The Drovers Solar Farm

Statement of Common Ground (SoCG) with Borough Council of King's Lynn and West Norfolk (Tracked)

Document reference: APP/5.20.1 (Revision 1)

The Drove, Swaffham Solar DCO	PROJECT
Ground Nesting Bird Strategy	TITLE
6806/GNBS2	DRAWING NO.
A/DO	REV
September 2025	DATE
LP/DO	QC

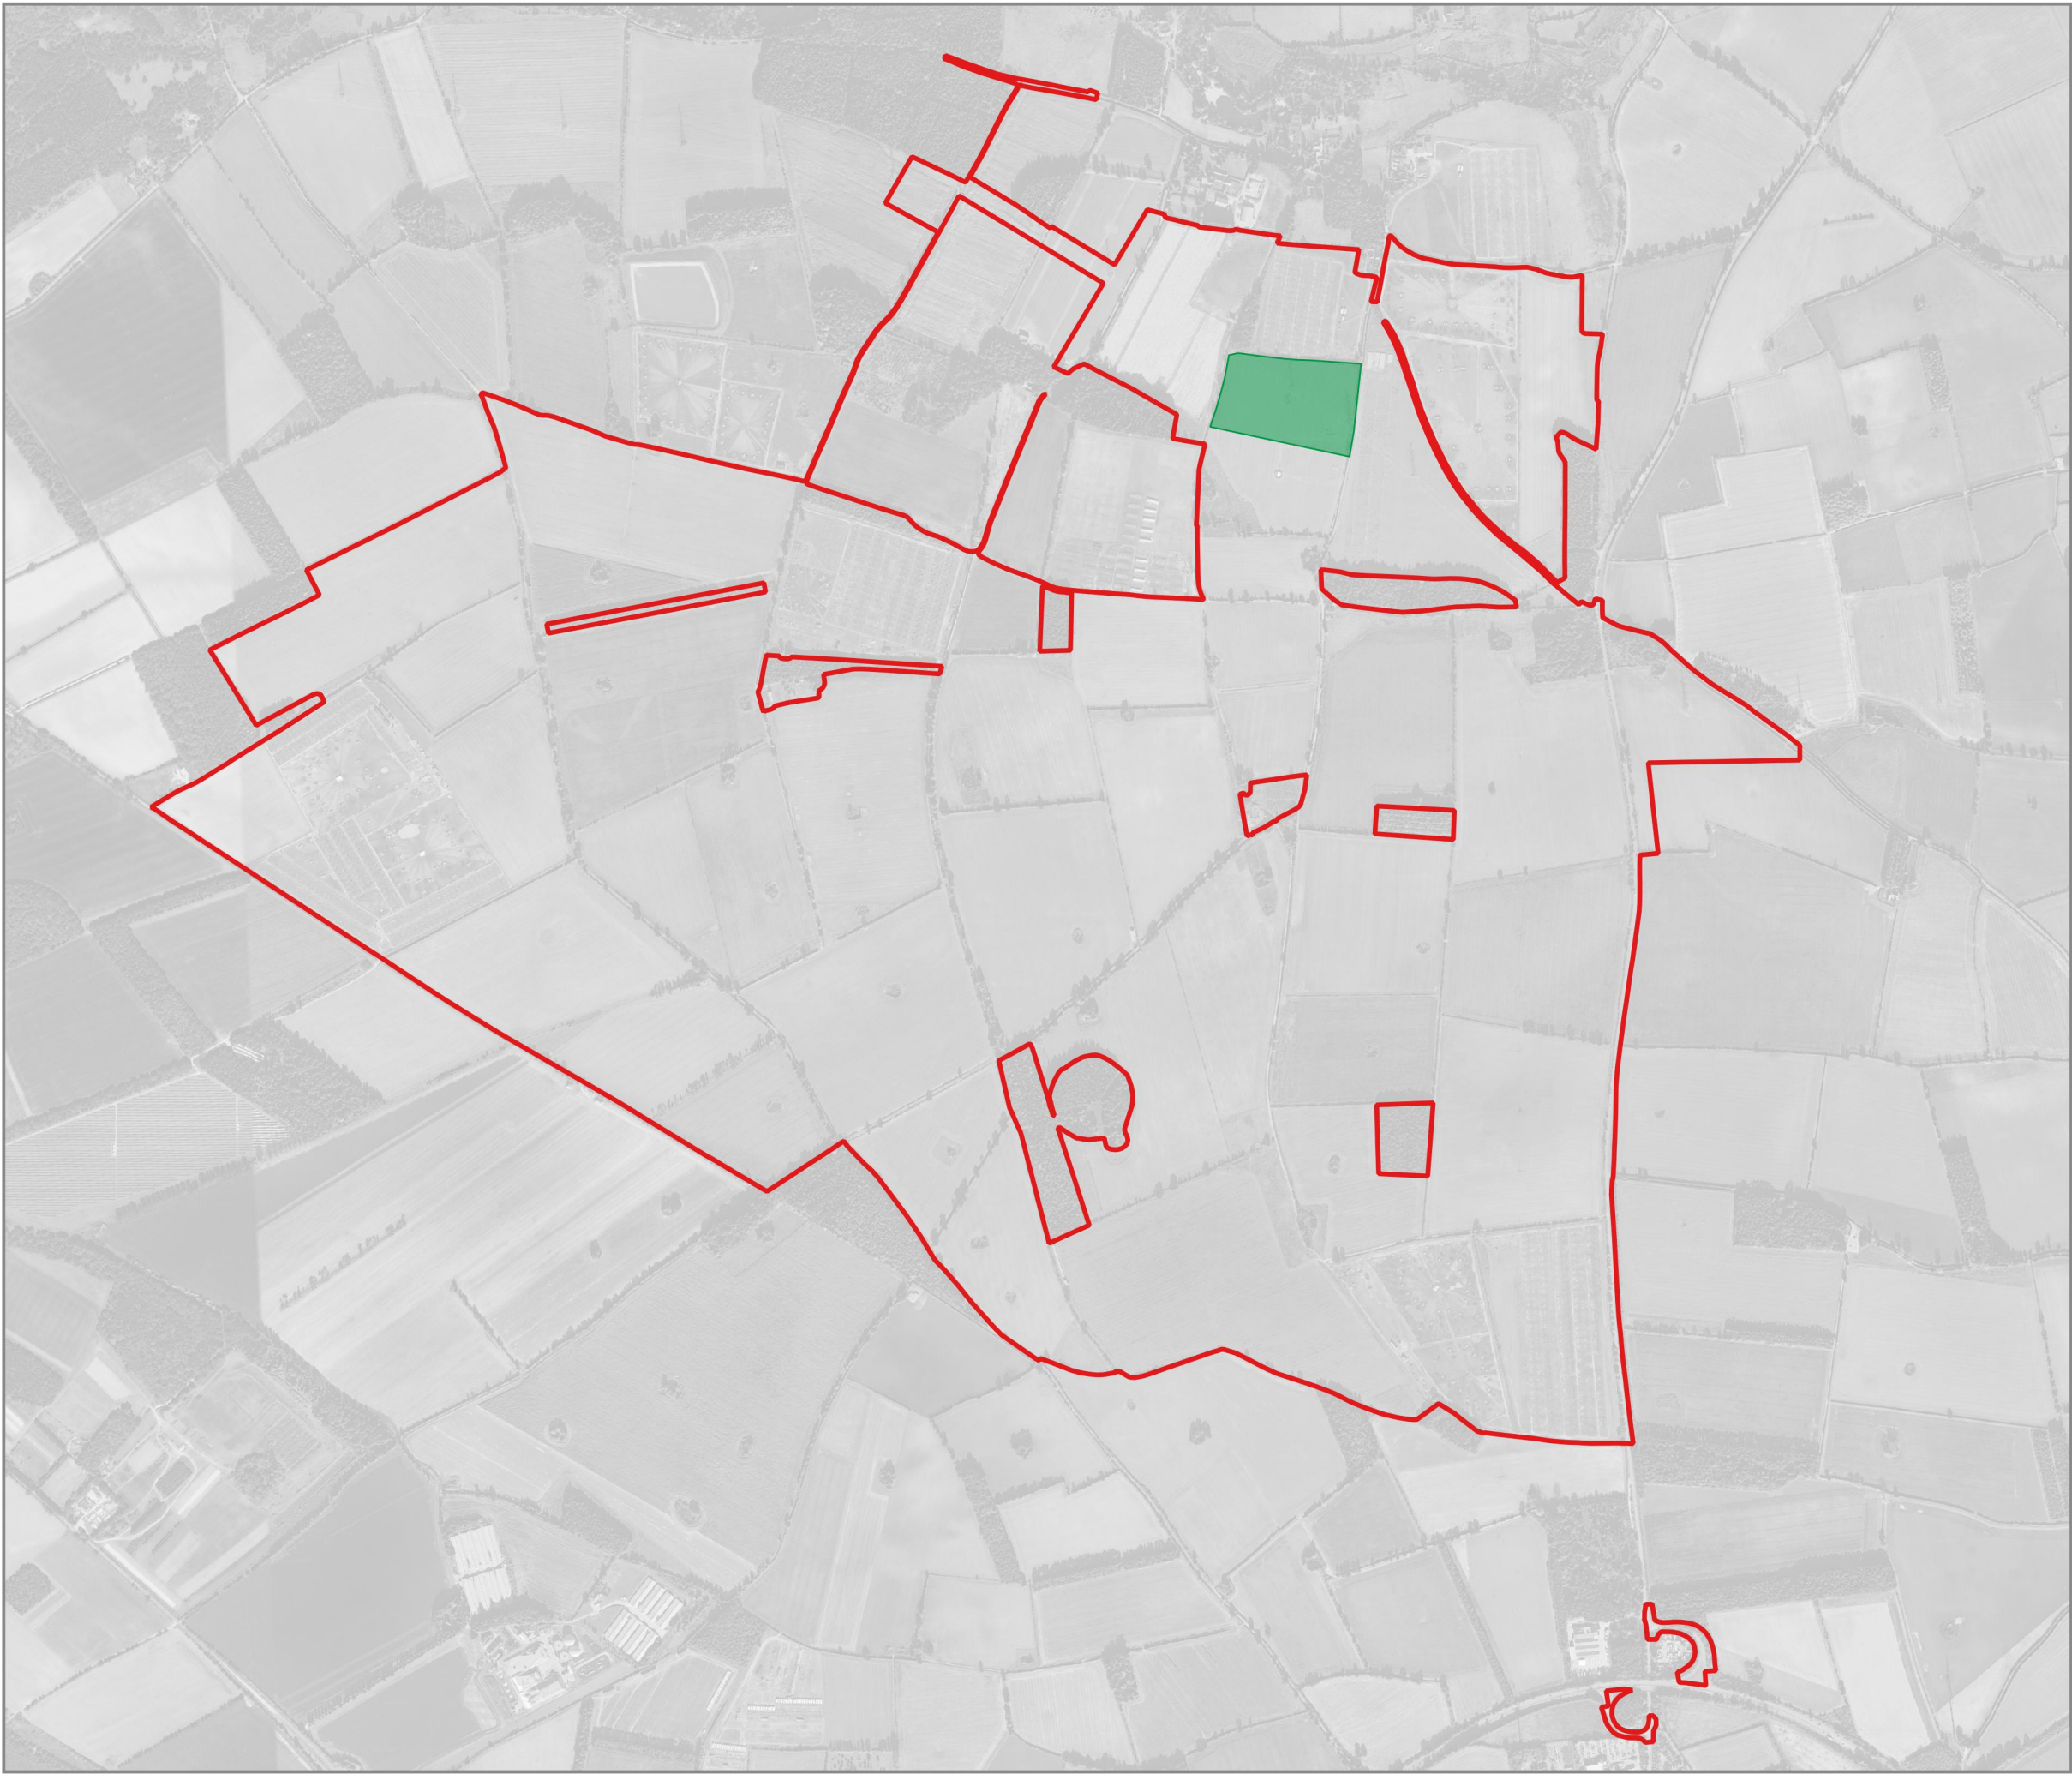
KLWN 3-5	Skylark Mitigation	The Council raise concerns regarding the methodology behind the plots provided for skylark mitigation at points 3.3.7 and 3.3.8 of the Local Impact Report [REP1-079]	As set out within the ES Appendix 7.3: Proposed Mitigation Strategy for Ground Nesting Birds Requiring Open Habitats [APP-149], the methodology used in relation to calculation of Skylark mitigation follows the approach set out within published methodology (Fox, 2022). As set out, the initial input figure of 117 pairs has been used in relation to the development footprint (i.e. excludes the 4 pairs within field 32 which is outside of the Scheme's boundary but includes the existing pairs within Fields 33 and 35 and as such these are taken into account). In relation to territories that could be absorbed within 75m of the development edge habitats, in line with the published methodology this relates to an increase in capacity over the existing use due to increased foraging	Under Discussion

habitat in proximity to the edges of the development and accordingly, the exclusion of the existing pairs within Field 32 from the calculations is no different from that within surrounding fields elsewhere, which would be anticipated to support a baseline of Skylark usage, and therefore consistent with the published methodology.	
KLWN 3-6	Impact on Protected Sites	Subject to compliance with the outline Construction Traffic Management Plan and outline Construction Environmental Management Plan, the Council raises no objection in regard to impacts on Protected Sites.	This is noted by the Applicant	Agreed
KLWN 3-7	Request for Habitat Monitoring and Management Plan	The Council request for a Habitat Monitoring and Management Plan to be secured through the DCO, notwithstanding the outline LEMP already submitted.	This is noted and agreed by the Applicant	Agreed

Figure 6.15: PM8, PM12 and PM14 Summer Photomontages - Illustrative Scheme (Part B) (Tracked)

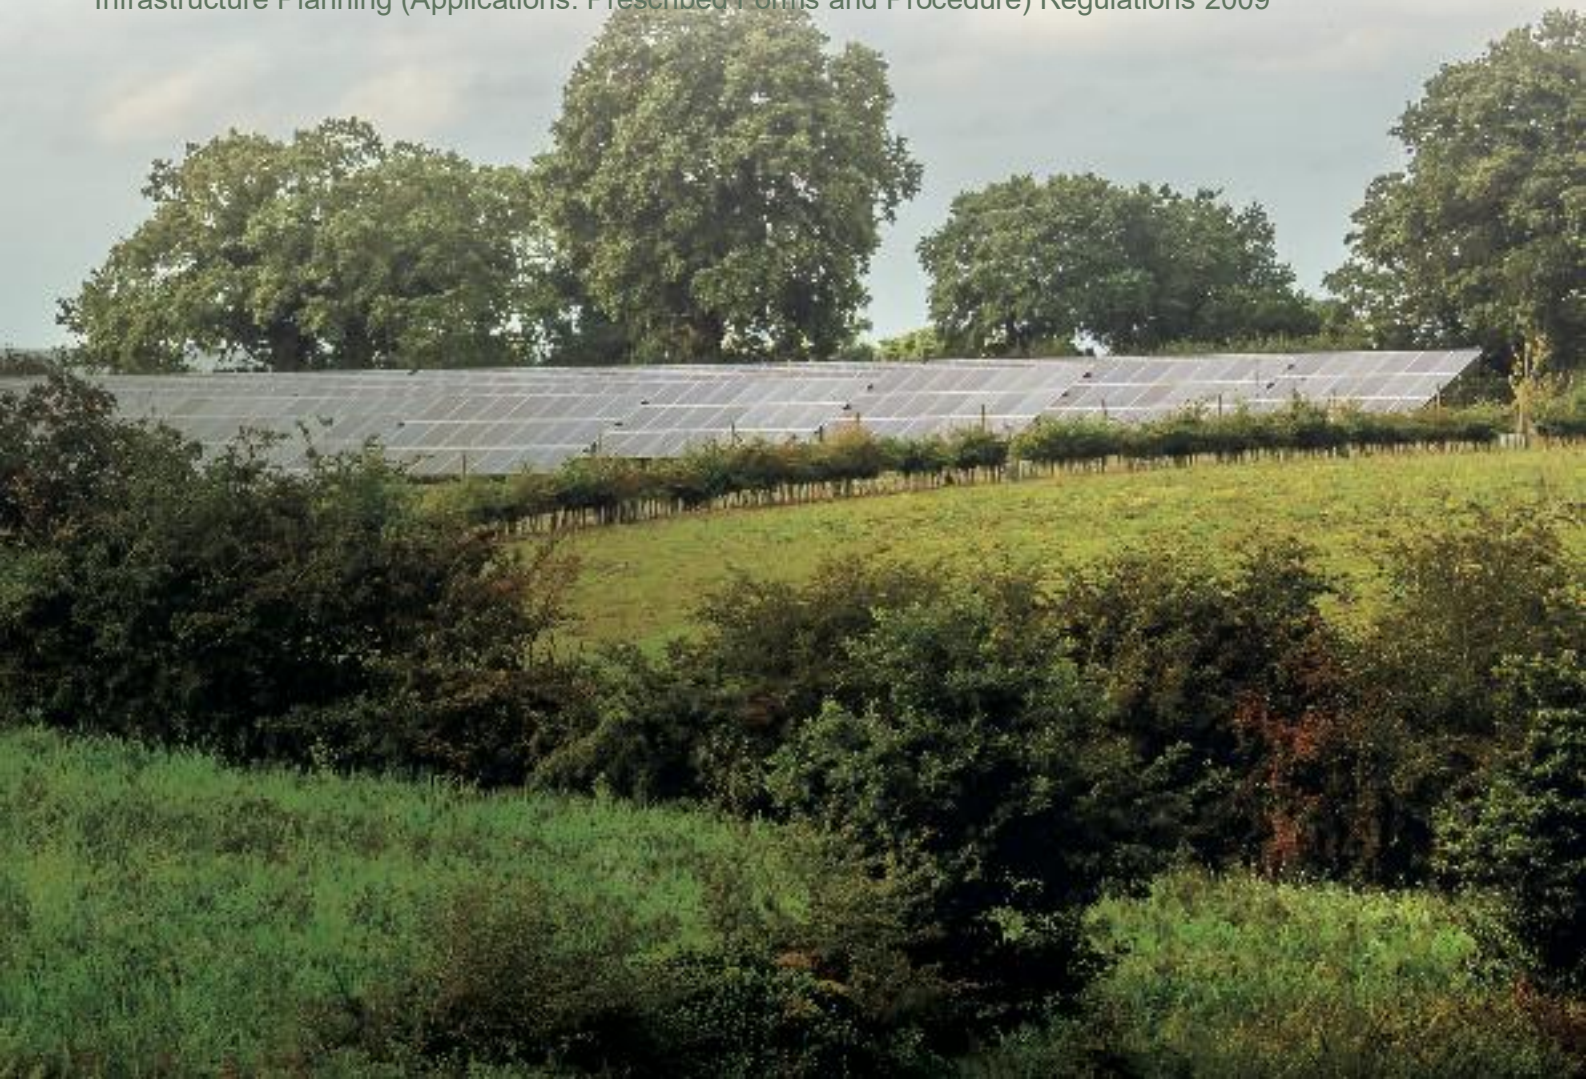
KLWN 1-2	Key Views	The Applicant has worked with the Borough Council's planning and heritage teams to reduce harm as much as possible. Moving the substations out of direct view from Castle Acre and placing them south of Bartholomew's Hill Plantation would not eliminate harm but would filter views and lessen visual impact. Removing solar PV from the northern part of field 33 is also positive, as the topography means the remaining panels would sit beyond the crest and be barely visible.	There is no anticipated substantial harm to, or total loss of, any designated heritage assets' significance as a result of the Scheme. ES Chapter 8: Cultural Heritage and Archaeology [APP-057] outlines that 'substantial harm' is afforded to any adverse effect that is of a major magnitude, whilst moderate, minor or negligible adverse effects represent effects that are of 'less than substantial harm' in nature. As detailed in the submitted visualisations (ES Figure 6.14: PM8, PM12 and PM14 Winter Photomontages - Illustrative Scheme [AS-039] and ES Figure 6.15: PM8, PM12 and PM14 Summer Photomontages - Illustrative Scheme [AS-045]), the National Grid	Medium

Substation and the Customer Substation will be entirely screened by Bartholemew's Plantation in views from the north, thereby removing, rather than reducing, visual impact. As described in ES Chapter 8: Cultural Heritage and Archaeology [APP-057] , new pylons will be visible, but not other elements of the National Grid Substation and the Customer Substation.	
KLWN 1-3	Level of harm outlined within ES Chapter 8	The Council disagree with the assessment and level of harm that has been attributed to the development within ES Chapter 8: Cultural Heritage and Archaeology. The Council maintain that as an integral part of the significance of the Castle and Conservation Area at Castle Acre, this change in land use would result in less than substantial harm, moderate in scale, to the significance of the castle at castle acre and a moderate level of less than substantial harm to the setting of Castle Acre Conservation Area.	In terms of the scales of impact as defined in ES Chapter 8: Cultural Heritage and Archaeology [APP-057] in order to be a moderate impact there would need to be considerable harm to a heritage asset's setting, such that the asset's significance would be materially affected/considerably devalued, but not totally or substantially lost. This is a relatively high level of impact which is not reflected by the Scheme, which would retain the village siting, the visual and spatial connection between the assets, the connection to the Peddars Way and the vast majority of the surrounding landscape visible from the heritage assets. The majority of views will be unchanged, with only very small elements of the wider Scheme remaining. Whilst the overall Scheme is large in scale the aspects of the settings of the designated heritage assets that will be subject to change have been minimised through embedded mitigation measures. The Applicant is satisfied that the levels of harm identified within ES Chapter 8: Cultural Heritage and Archaeology [APP-057] (Scenario A – Minor, Scenario B – Neutral) are robust and justifiable.
